DFT PR-2024-010446

SI-2024-00774

RESPONSE TO: Code Enforcement Comments

4 MONUMENT STREET SIGN SPECS

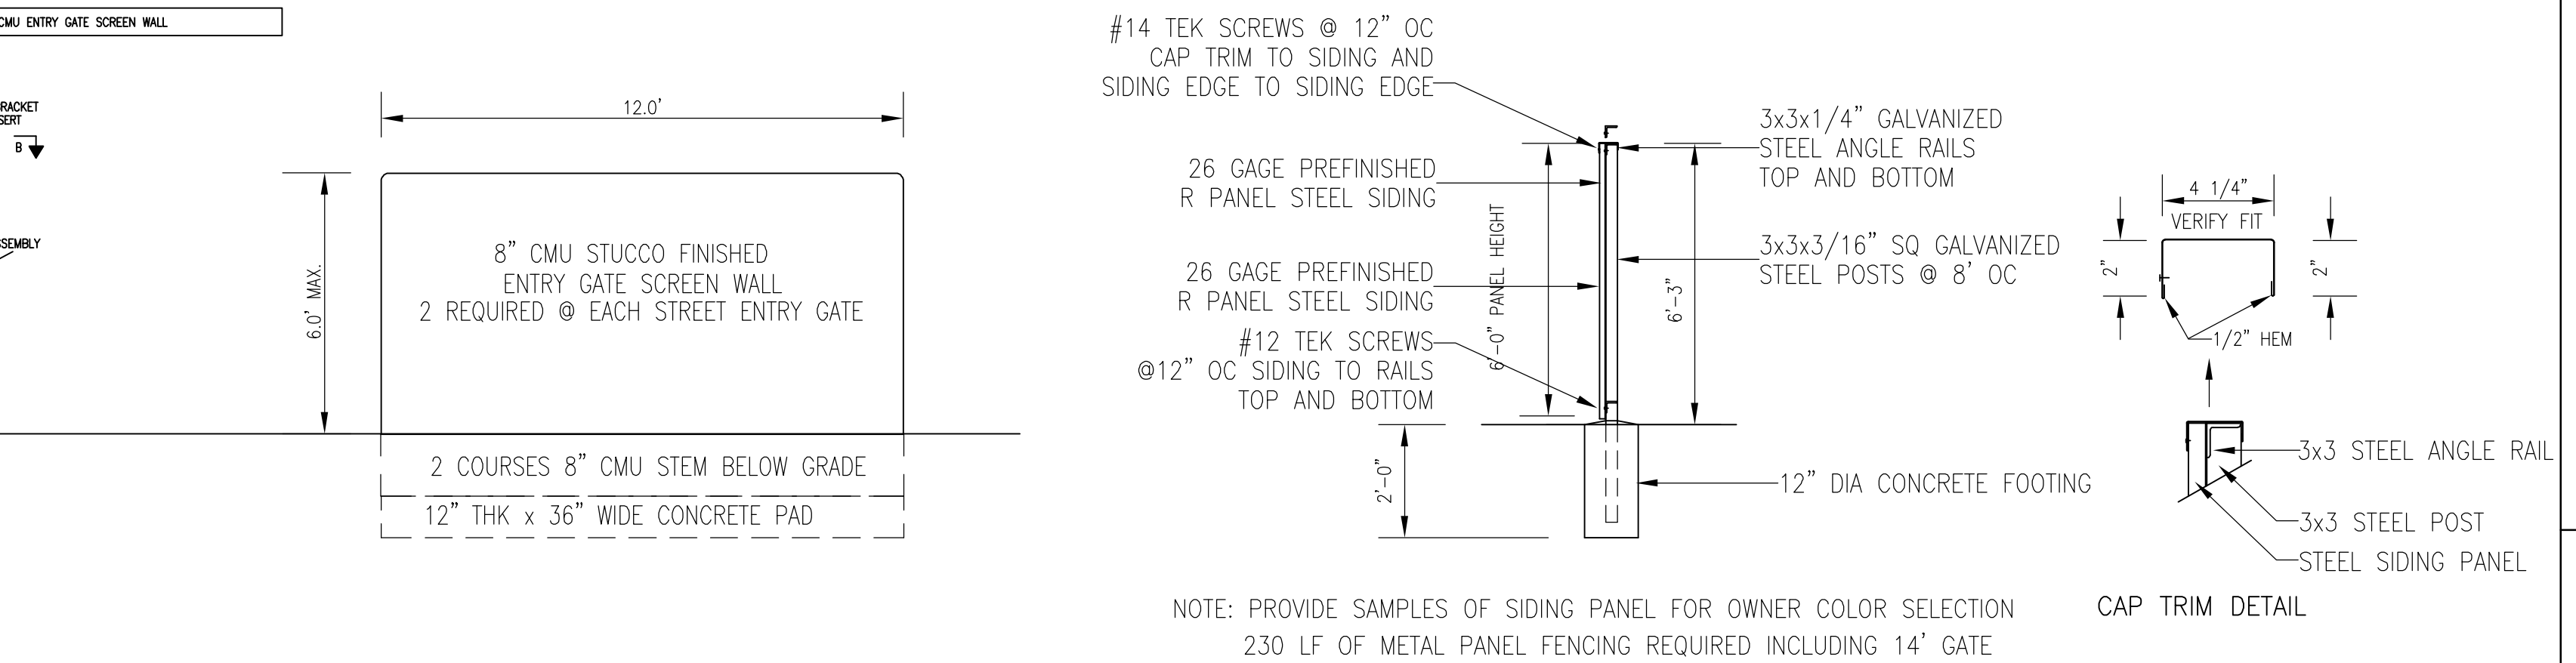
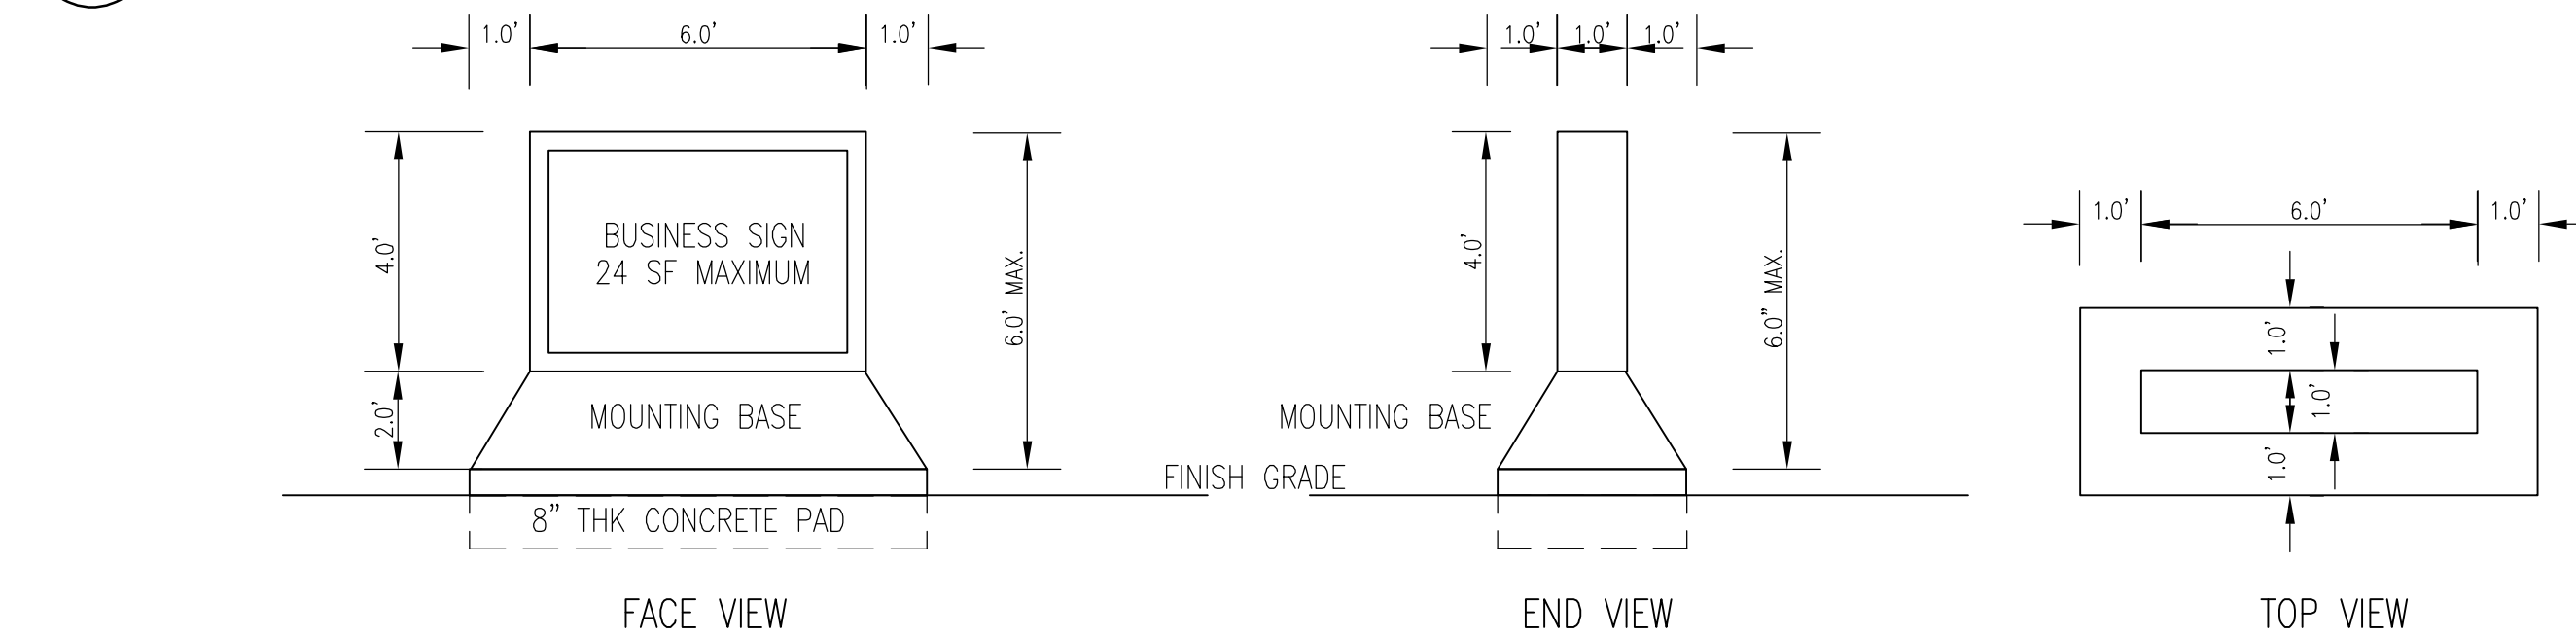
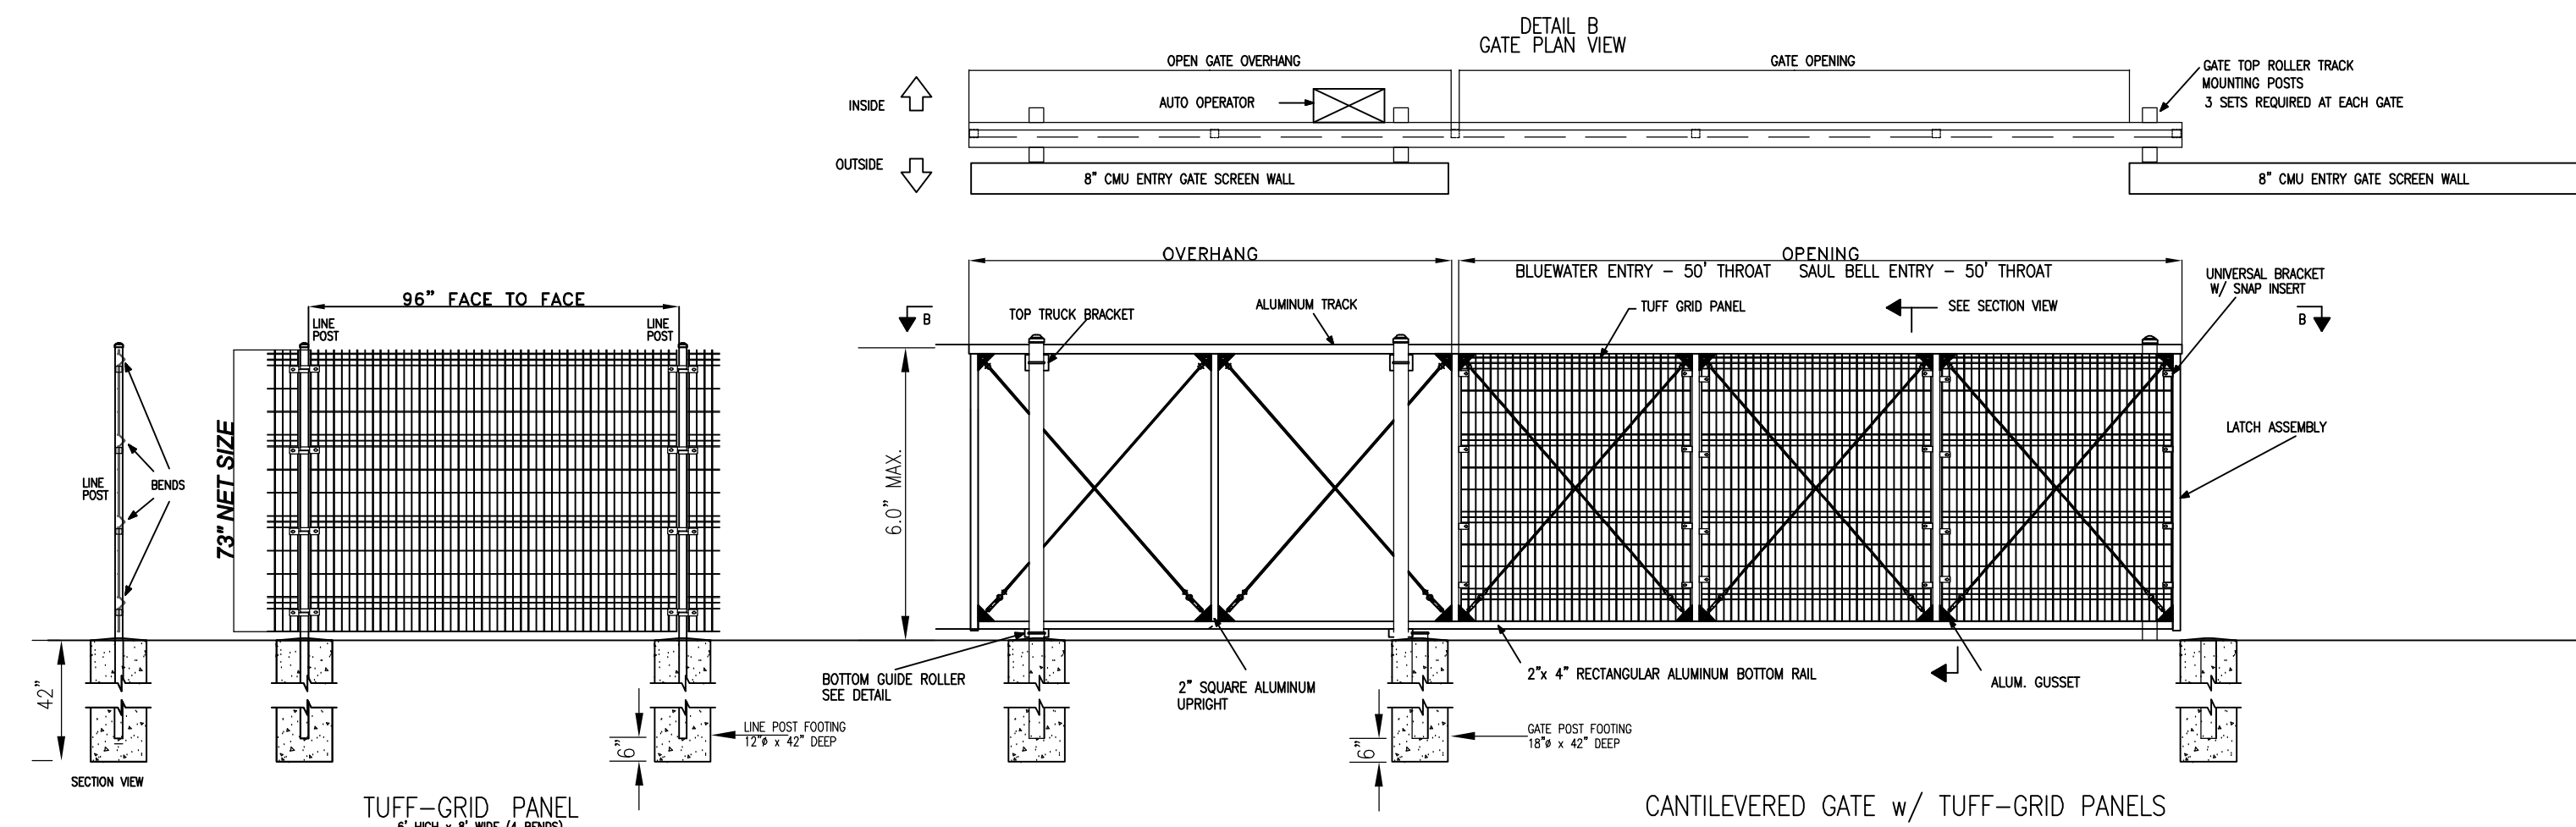
3. --Signage within NR-BP is per the plan. A signage plan would need to be submitted with your site plan. It will need to meet the CP plan and where silent, the IDO. Or signage can be done through building permit by using both the CP plan and NR-C standards.

For example, in the IDO the only signage allow along Unser are wall signs and freestanding, not rooftop. Electronic signage/LED message boards are prohibited along Unser. CP plan calls out specific lighting/illumination for signage.

Freestanding signs must be at least 3ft away from any property line and are limited in size along Unser. As mentioned, the CP plan calls out signage standards as well:

RESPONSE: See drawings AC1 and AC2 for location and construction of the Monument Sign near the Unser/Bluewater intersection. This sign area is 24 square feet and will be face lighted. This sign is designed with two faces and is positioned on a diagonal axis so that a sign face is readily visible to Bluewater and Saul Bell roads and in both directions of traffic flow.

3 PERIMETER WIRE FENCING

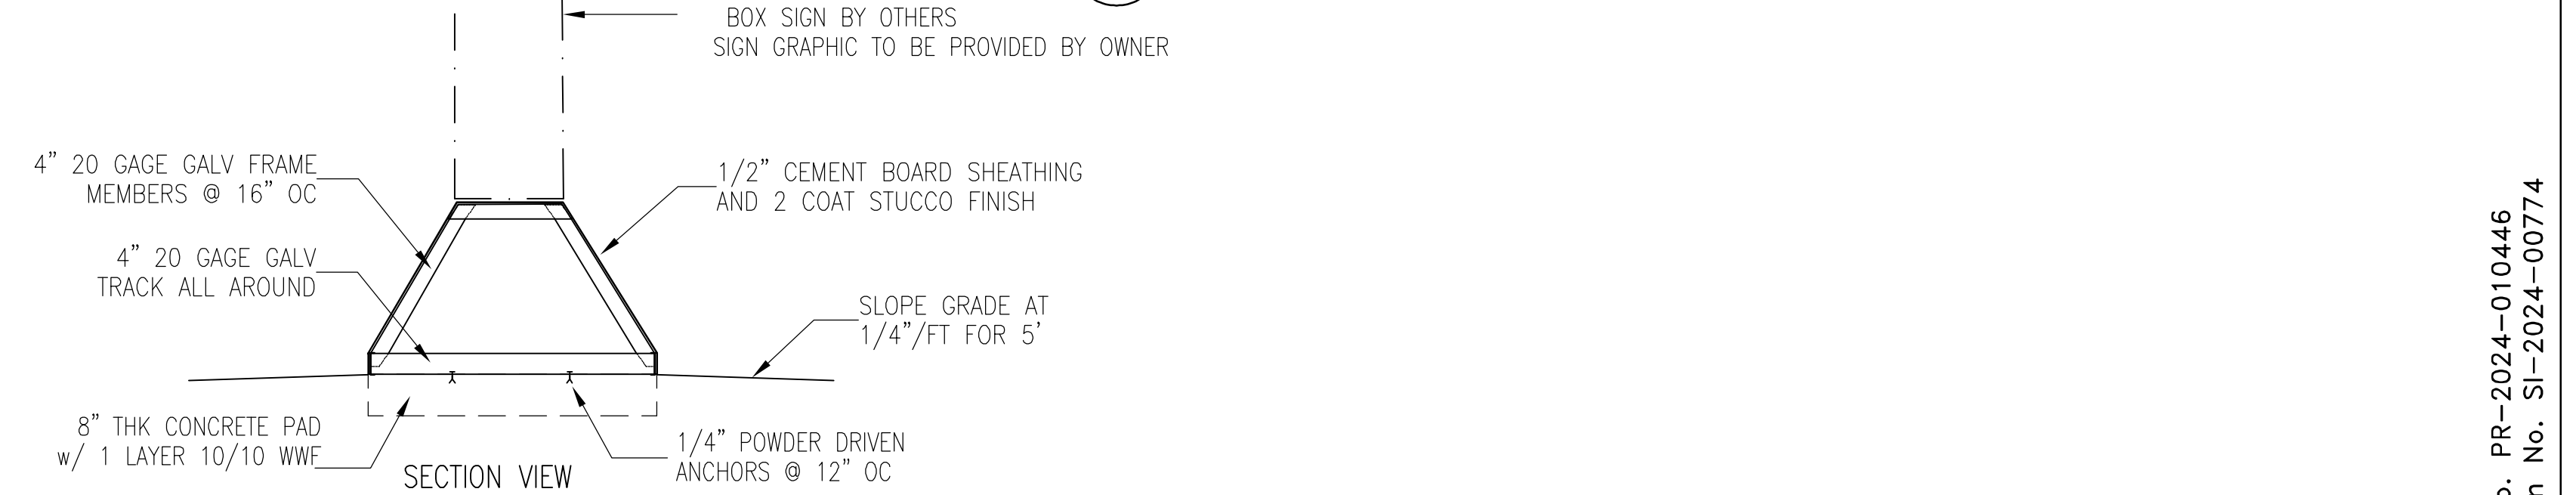
- **Confirm with Code Enforcement that the proposed metal fencing is meeting the material requirements of the Clifford West Plan and/or IDO standards.**

The CWBP does not provide any discussion of fence materials or design. The 6’ high, 3 crimp wire fencing specified for this project is the same as that which the City has commonly used for perimeter fencing of playgrounds and other public activity areas. Separate fencing permit has been applied for (GP-2024-16832).

ADDITIONAL RESPONSE: See drawing AC2 for fence details and specifications. The same three (3) crimp wire fence as the City has installed in public parks and other areas, will be installed on the perimeter of this Development.

At the vehicle storage area near the Shop Building, prefinished metal panels, as allowed by the CWMP design criteria for “back of house” areas, will be installed to visibly isolate the storage area from the public.
